Subject: Proposed Revision to Plan for 2423 63rd Ave SE -Residential Project (Permit 2001-124)

To: Ruji Ding, PE – City of Mercer Island

**SITE & DRAINAGE
PLAN DETAILS**

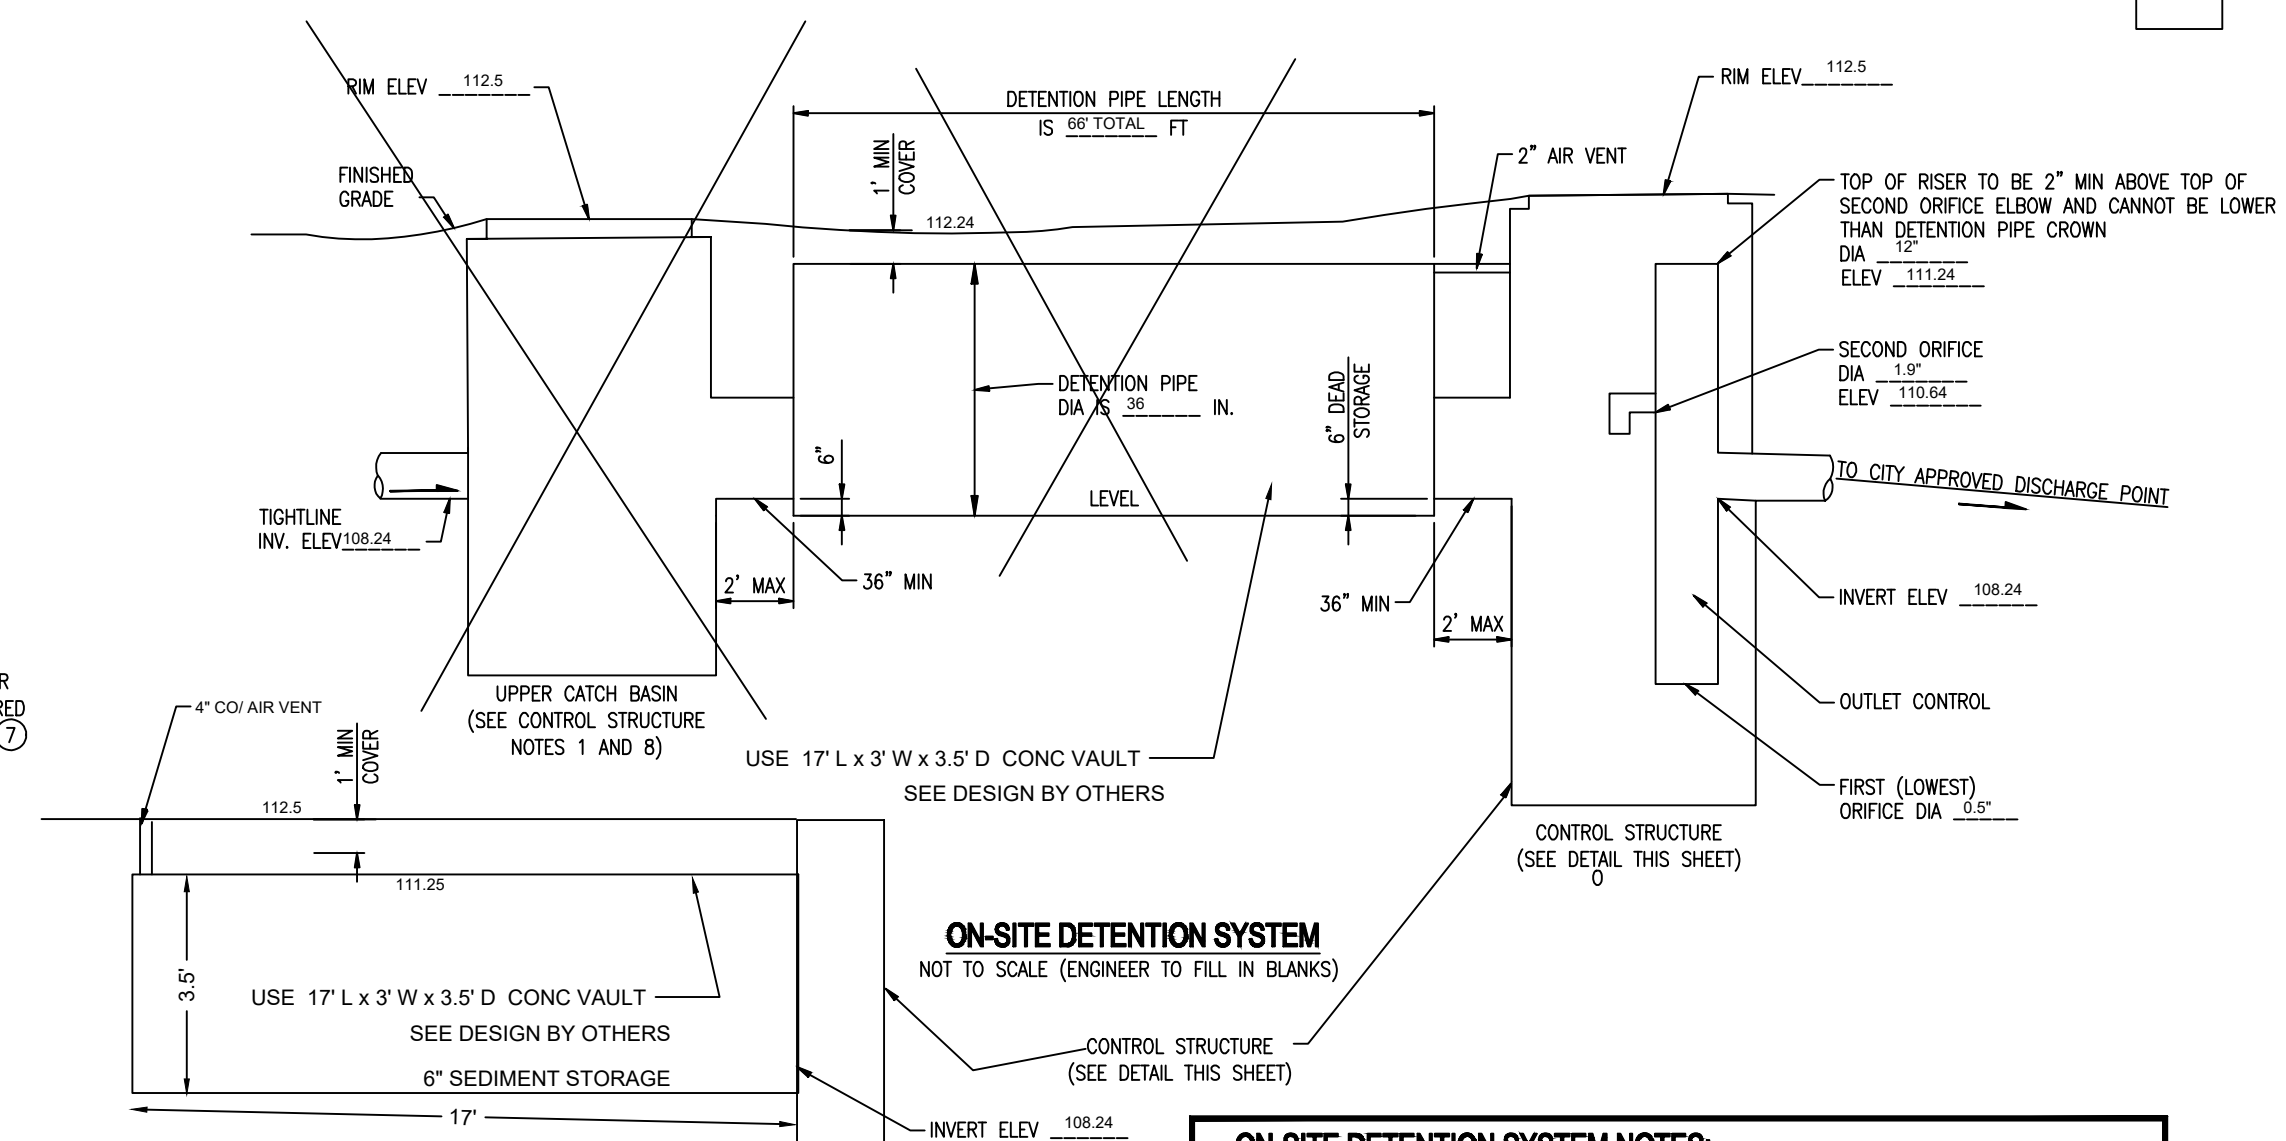
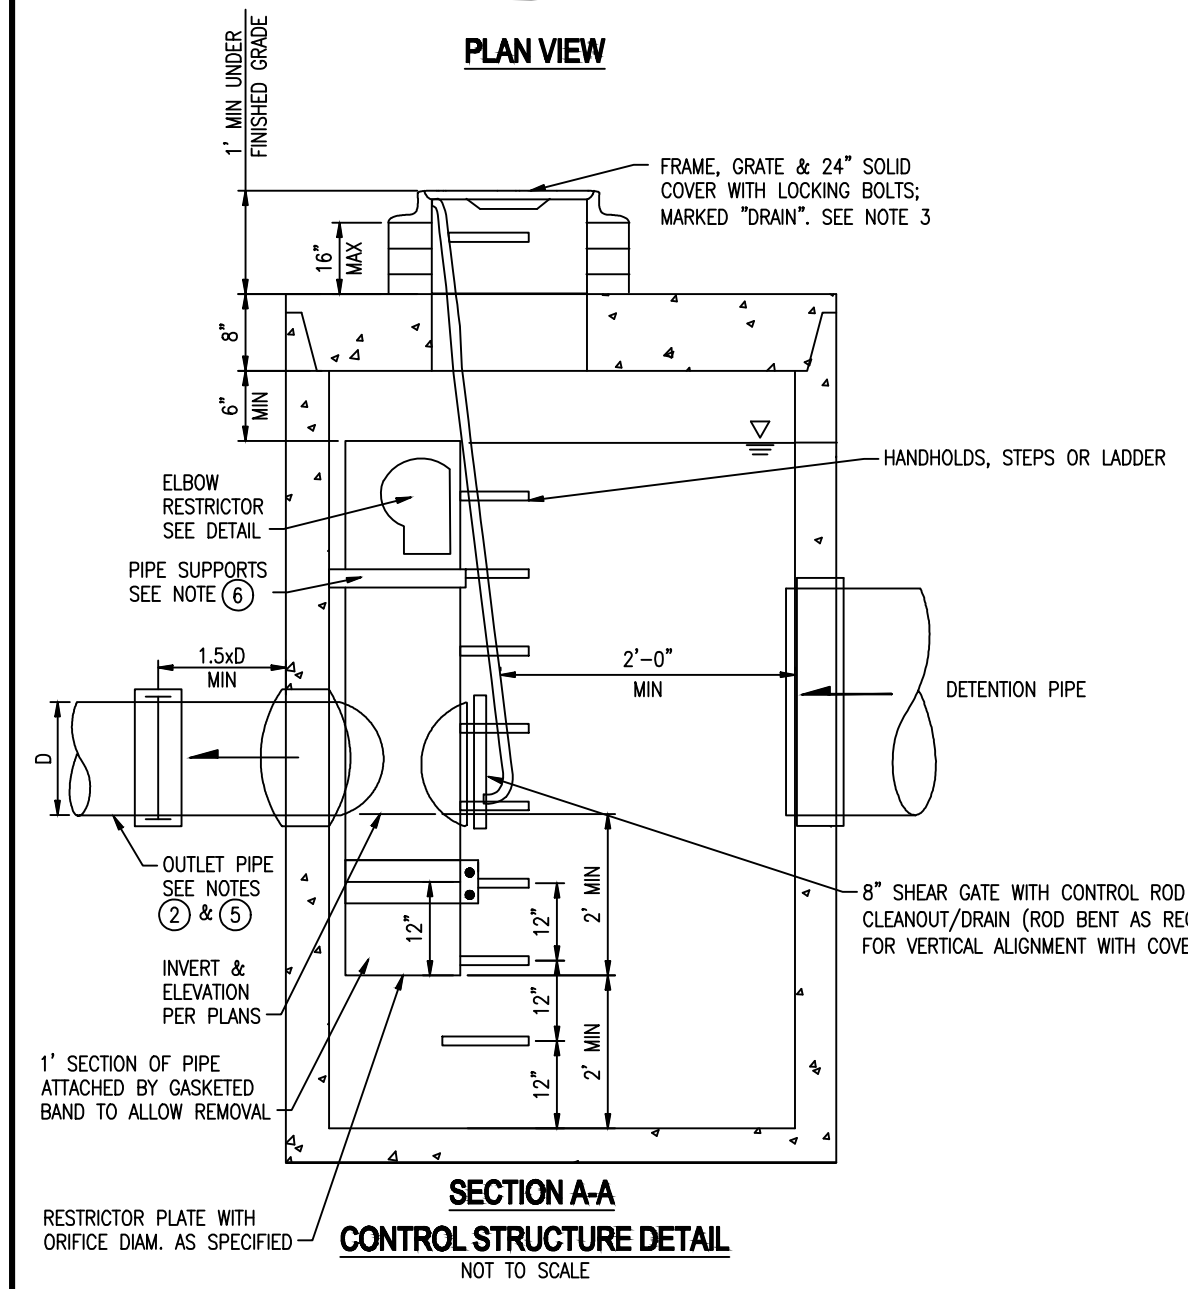
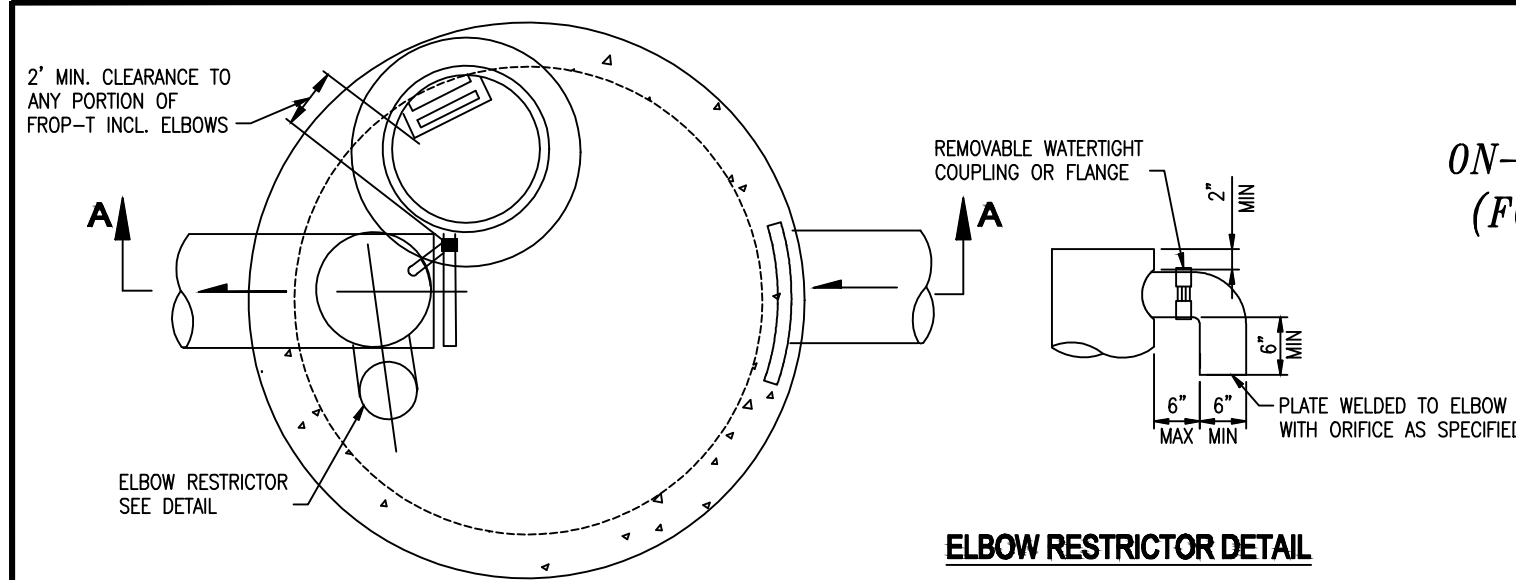
We have had difficulty finding economical 36 inch pipe and manholes to install for the drainage system for 2423 63rd Ave SE. Therefore we are proposing to use a Concrete tank 17 ft long x 3.5 feet high (including 0.5 feet of sediment storage) x 3 feet wide, to provide the Detention storage Requirement. See attached Plan and revised report. The tank will be designed by others to provide H2O loading capacity and the equivalent storage volume for the 66 lf of 36 inch Ø pipe required.
